**APPLICATION BY NATIONAL GRID ELECTRICITY TRANSMISSION (NGET) FOR SEA LINK  
FOR AN ORDER GRANTING DEVELOPMENT CONSENT FOR THE SEA LINK PROJECT**

**(REF: EN020026)**

**EXAMINING AUTHORITY'S WRITTEN  
QUESTIONS 3**

**RESPONSE BY THE PORT OF LONDON  
AUTHORITY**

Plate 2.1 Stakeholder areas of interest with regard to under-keel clearance

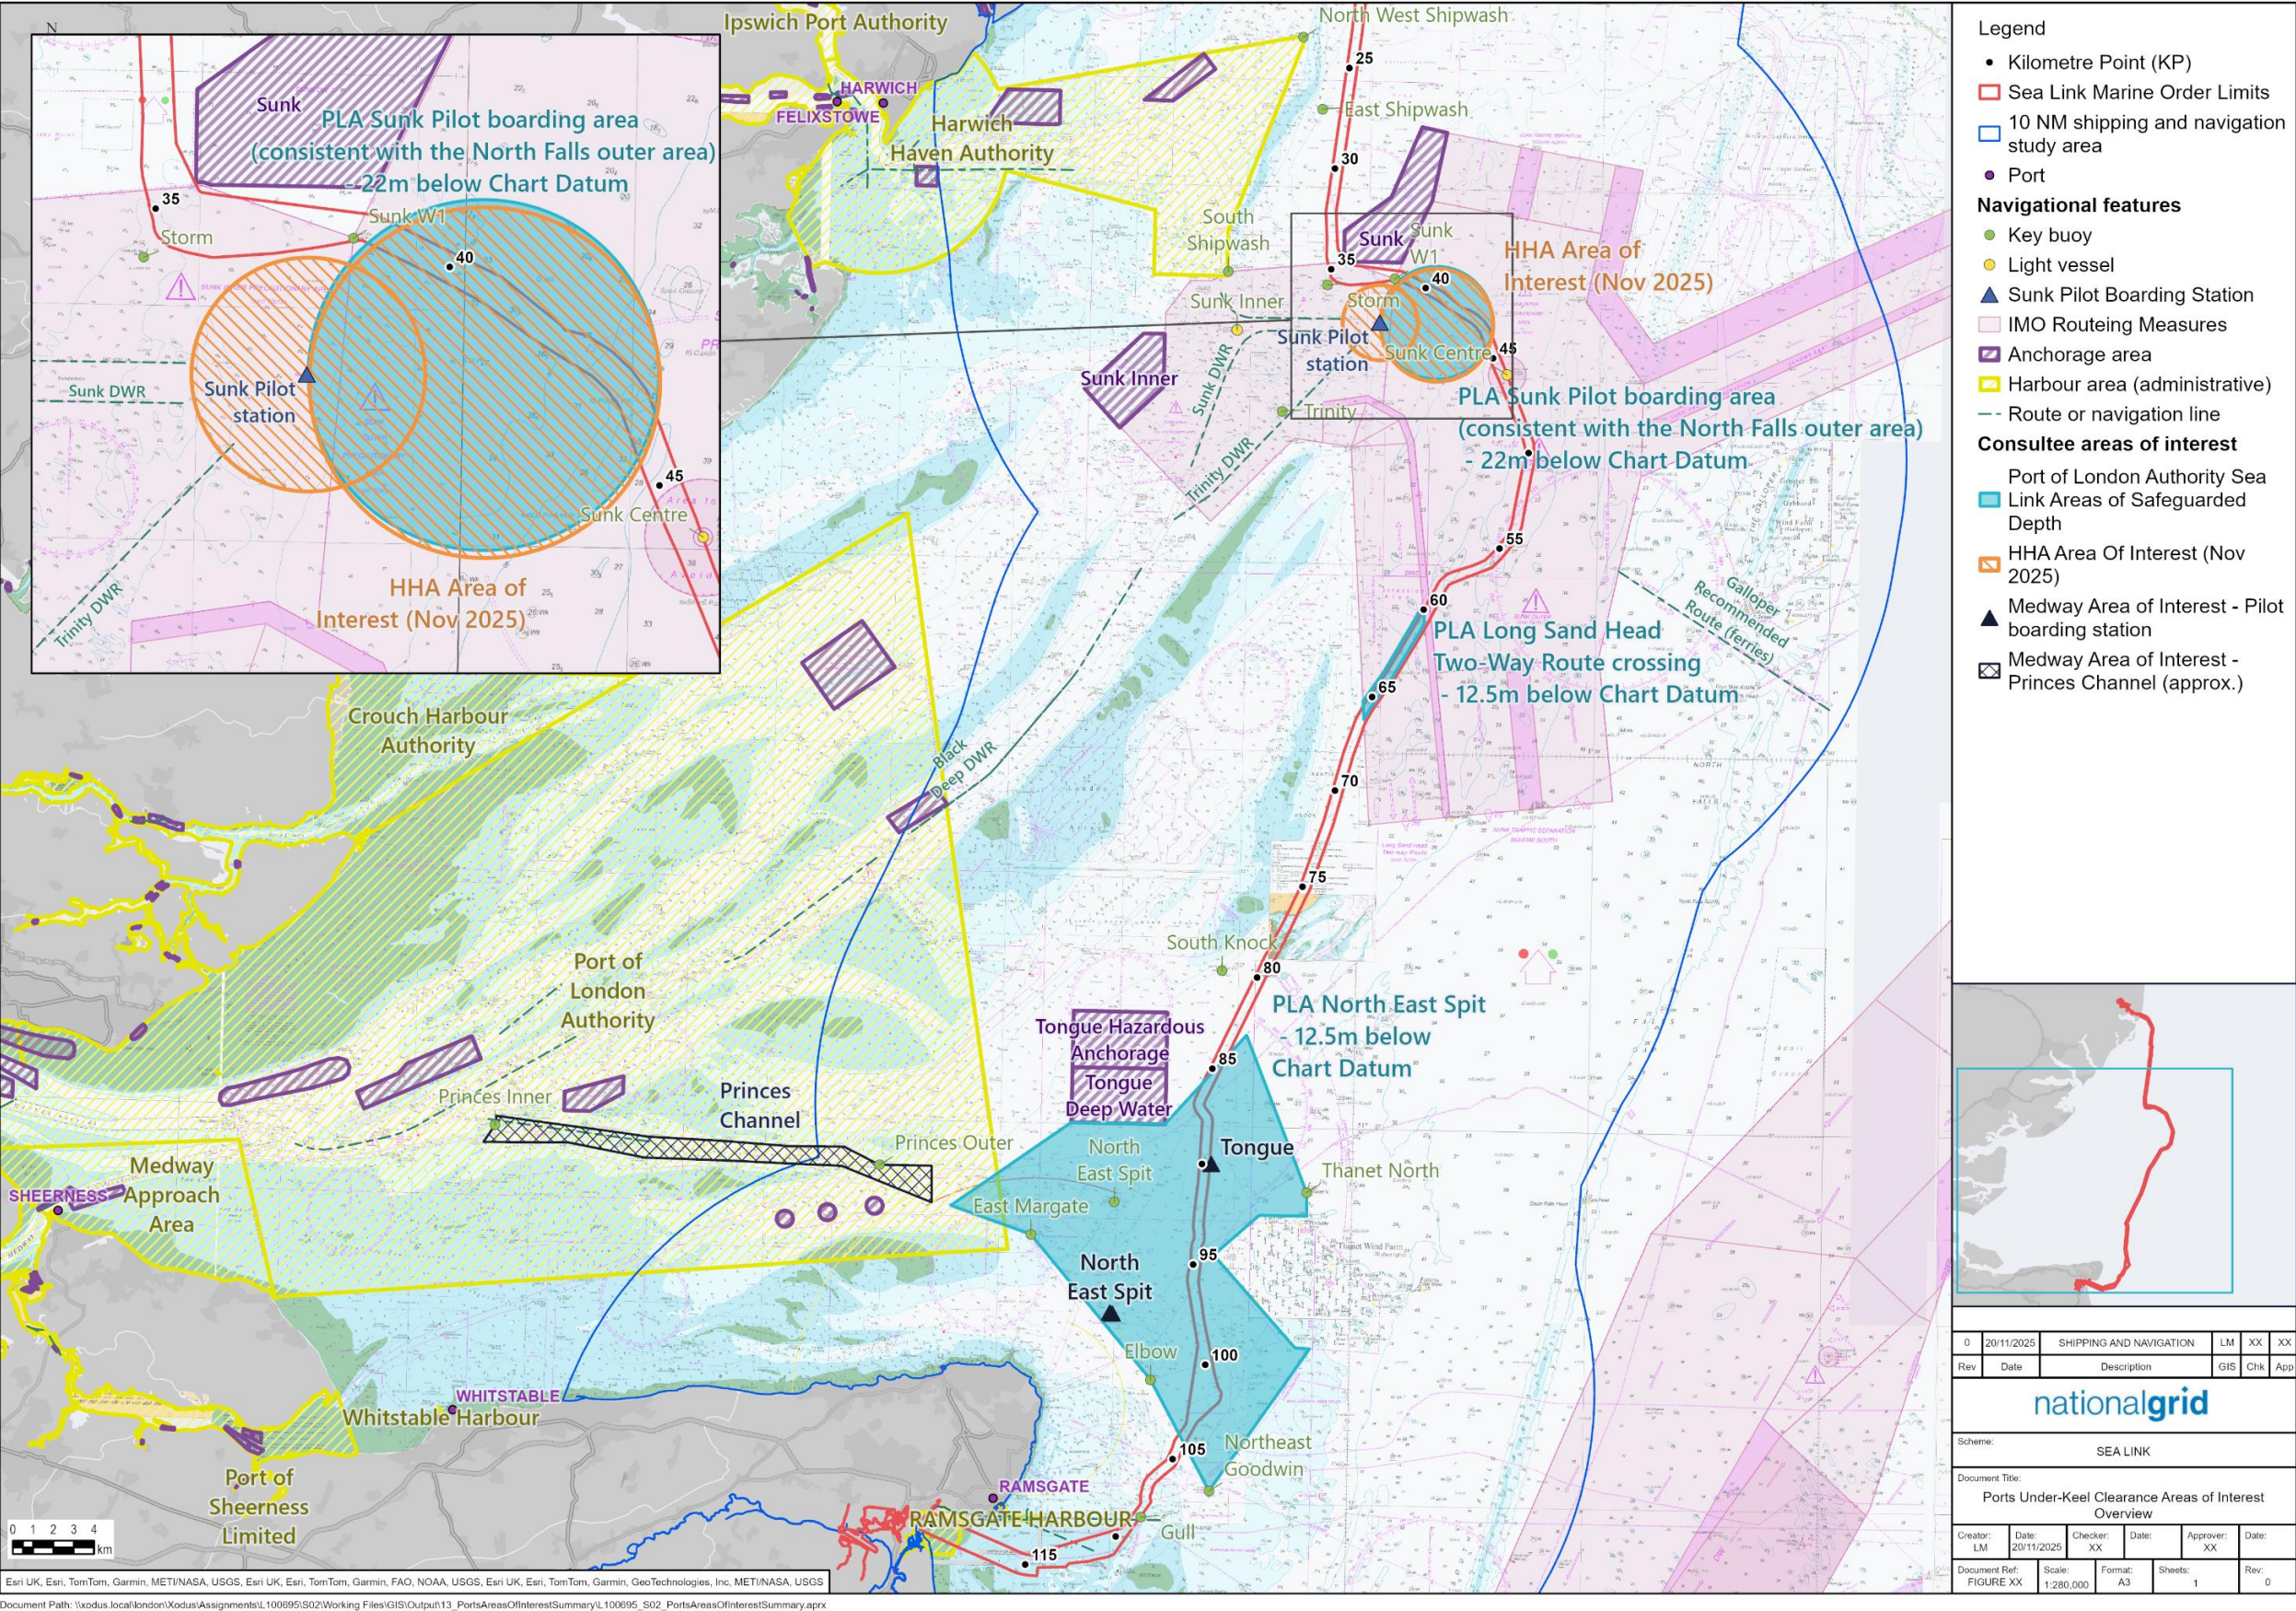
ExQ3	Question to:	Question:	PLA'S Response
<b>21. Shipping and navigation</b>			
3SN4	MMO	<p><b>Cable burial</b> Has the applicant's response in [REP5-132] to your concern in relation to cable burial depths from KP 96.343 to 113.83 [REP4-126] provided sufficient information? If not, what more do you require and why.</p>	<p>Whilst this question is directed to the MMO, the PLA confirms that it has no in principle objection if deeper cable burial was to occur between KP 96.343 and KP113.83.</p> <p>The PLA notes that the Applicant's response in REP5-132 includes confirmation that they will update the Cable Burial Risk Assessment ("CBRA") post consent based on the additional requirements for deeper burial identified by stakeholders during examination. It is unclear to the PLA where this commitment is secured. There is no commitment for example in the Register of Environmental Actions and Commitments ("REAC") [REP5-116].</p>

ExQ3	Question to:	Question:	PLA'S Response
			<p>The minimum DoL as set out in the CBRA (page 135) and oCSIP (para 4.3.9) to the top of the cable is 0.5m (in areas of bedrock) with a target depth of lowering of 1-2.5m depending on the hazards present in the area.</p> <p>The PLA had concerns that in parts of the Sunk Pilot Boarding area the DoL might increase from 2.5m to approximately 4.5m in the shallowest sections of the route (see Shipping and Navigation Under-Keel Clearance Marine Engineering Technical Note [REP1A-038]) and the PLA has since deadline 2 therefore been requesting that application documents were updated to reflect this additional lowering.</p> <p>At Deadline 5 the Applicant submitted Areas of Safeguarded Water Depth – Consideration of Additional Installation Requirements [REP5-139] and this sets out how pre-sweeping is now proposed at the Sunk Pilot Boarding area with the average depth of material to be removed being 1.5m. The Applicant has confirmed to the PLA that this pre-sweeping means that the subsequent cable lowering “remains 2.0m-2.5m below 22.5m CD”. As a result of this confirmation the PLA is content that the DoL information in the oCSIP and CBRA are consistent and that the documents do not require an update in respect of DoL.</p> <p>As set out above, the PLA notes that the Applicant’s response in REP5-132 includes confirmation that they will update the CBRA post consent based on the additional requirements for deeper burial identified by stakeholders</p>

ExQ3	Question to:	Question:	PLA'S Response
			during examination. It is unclear where this commitment is secured. There is no commitment for example in the REAC [REP5-116].
3SN6.	MCA MMO PLA LGPL HHA	<p><b>Anchor strike risk</b></p> <p>Provide clarification as to whether concerns regarding anchor strike risk, particularly in relation to the Sunk anchorage would be adequately mitigated by the mitigation measures including the target depth of lowering and external cable protection details set out in the oCSIP [REP4-090]. If not, provide details of any remaining concerns and/ or additional measures that would be required.</p>	As set out in para 5.1.8 of the oCSIP, the Applicant's primary method of cable protection is burial of the cable. The PLA has no in principle concerns with this but would be concerned if target DoL was not achieved and then as set out in 5.1.7 of the oCSIP the Applicant looked to add protection in the form rock placement as this could impact water depths. If target DoL is not met and concerns remain regarding anchor strike, remedial works must be undertaken to lower the cable to the required depth.

Plate 1.1 Areas of Safeguarded Water Depth

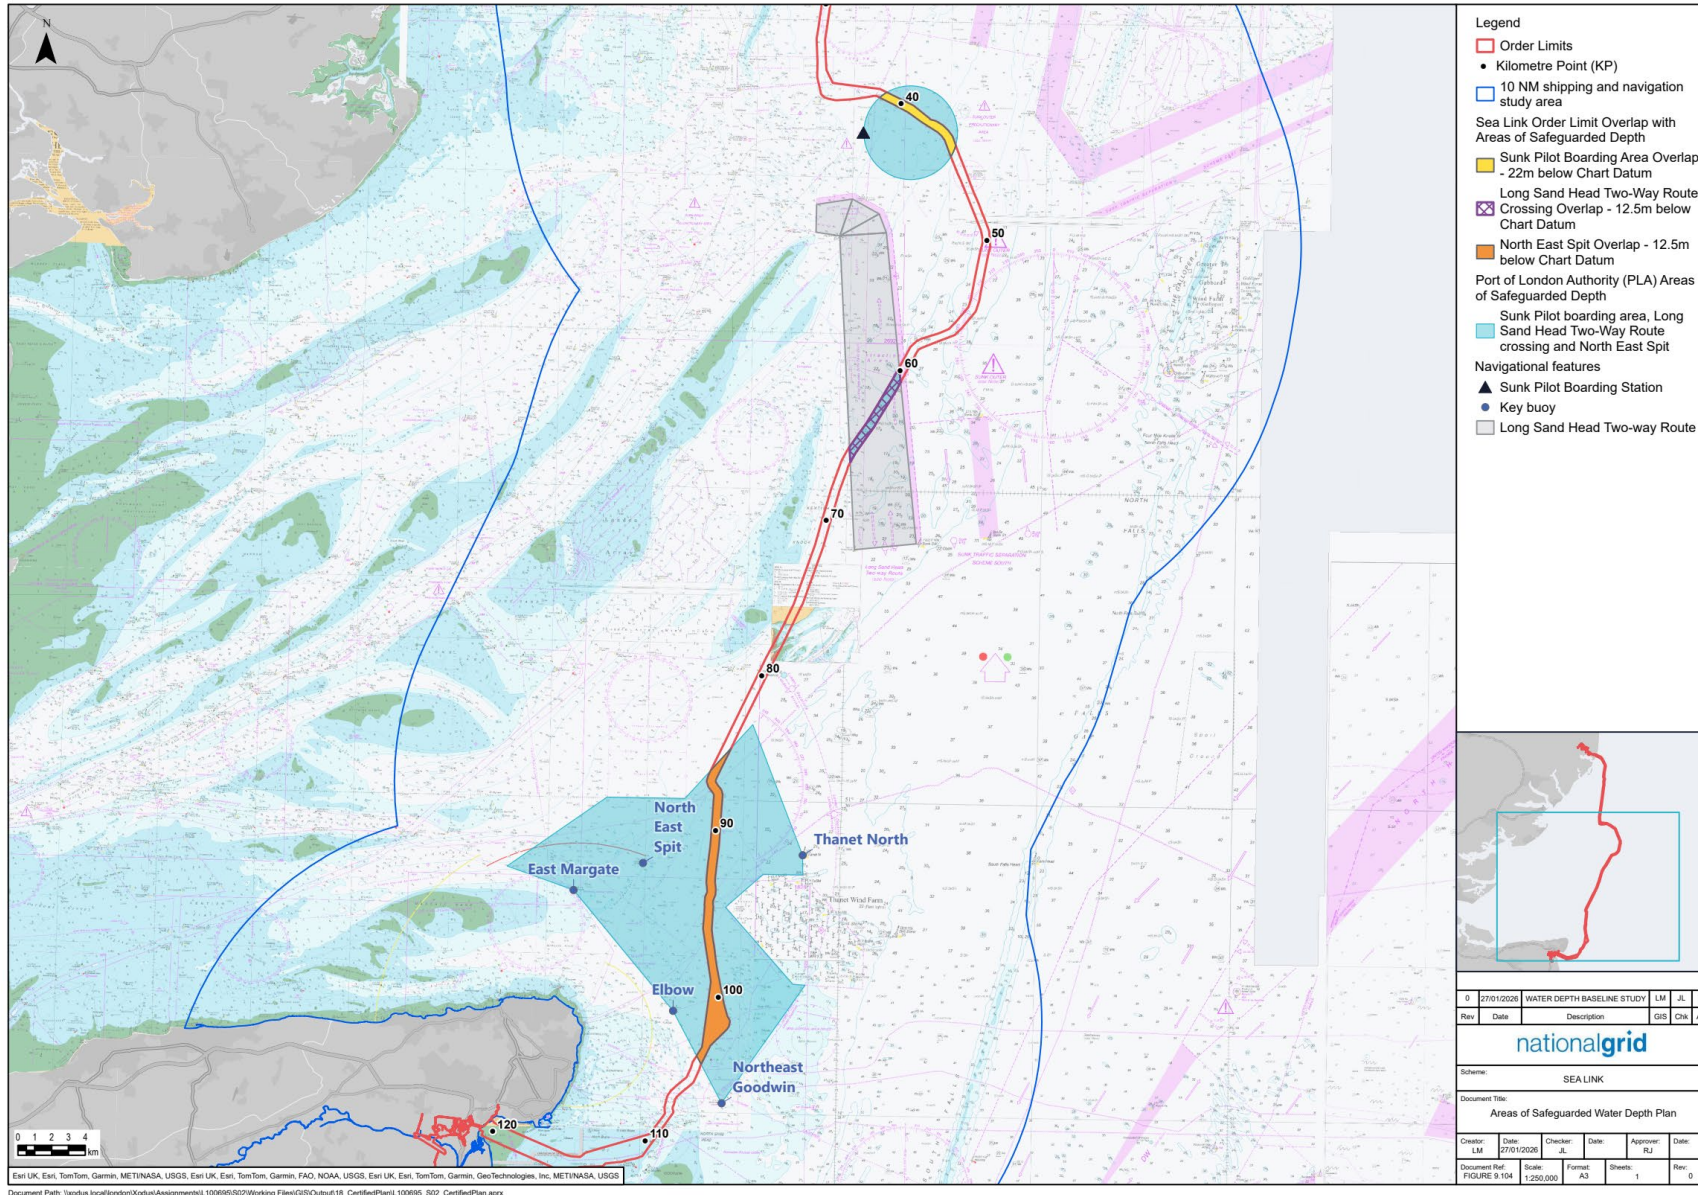
3SN14.	MMO MCA PLA LGPL HHA	<p><b>Planned cable joints within the three areas of safeguarded depth (ASD) on plate 1.2 of [REP4-090]</b></p> <p>The oCSIP sets out in section 4.4 that there will be no planned cable joints in the three</p>	<p>The oCSIP advises at para 4.4.4 that there are no planned cable joints within the three Areas of Safeguarded Depth, excluding the need for any unforeseen repairs during installation and/or the operational lifetime.</p>

ExQ3	Question to:	Question:	PLA'S Response
		<p>ASDs. Is this sufficient to minimise risks to shipping and navigation to ALARP and mitigate any likely significant effects on shipping. If not, explain the additional measures that are required, and if appropriate provide suggested wording.</p>	<p>The dDCO submitted at deadline 5 includes at Part 2 Condition (3) that in the Areas of Interest there are to be no cable joints as part of the construction or maintenance of Work No. 6 (unless necessitated by emergency maintenance works).</p> <p>The PLA is therefore satisfied that there will be no planned cable joints in the three Areas of Safeguarded Depth.</p>
3SN16.	MMO MCA PLA LGPL HHA	<p><b>Unplanned cable joint repairs</b></p> <p>Condition 12 of the dDML [REP5-005] sets out that 'maintenance' includes cable repairs. REAC provision SN33 states that unplanned cable repair joints will be avoided in the Sunk, so far as practicable, but if such a scenario is unavoidable, the project shall consider potential collision risk and minimize time spent during maintenance in this region as much as possible. The oCSIP [REP4-090] sets out in section 4.4 further detail of the procedure for cable jointing and unforeseen repairs within the three areas of safeguarded water depth. Consider whether these provisions provide adequate safeguards to minimise risks to shipping and navigation to ALARP in</p>	<p>The Applicant cannot predict where a cable joint may be required during operation/maintenance and The Description of the Proposed Project [REP1A-004] advises at para 4.10.19 that where possible a repair agreement would be in place with provision for a minimum of 5 repair joints.</p> <p>REAC provision SN33 seeks to avoid cable repairs joints in the Sunk, so far as practicable. This is welcomed but the PLA accepts that the Applicant may ultimately have to repair the cable within the Sunk area at which point SN33 considers potential collision risk and seeks to minimise the time spent in the region as much as possible. The PLA considers that there is a balance to be struck between minimising time in the Sunk area and the impacts of the solution that is being proposed. For example, a quicker solution could be to repair the joint and leave the cable on the seabed with rock protection over it. This would be a sub optimal solution to being in the Sunk area for a longer period</p>
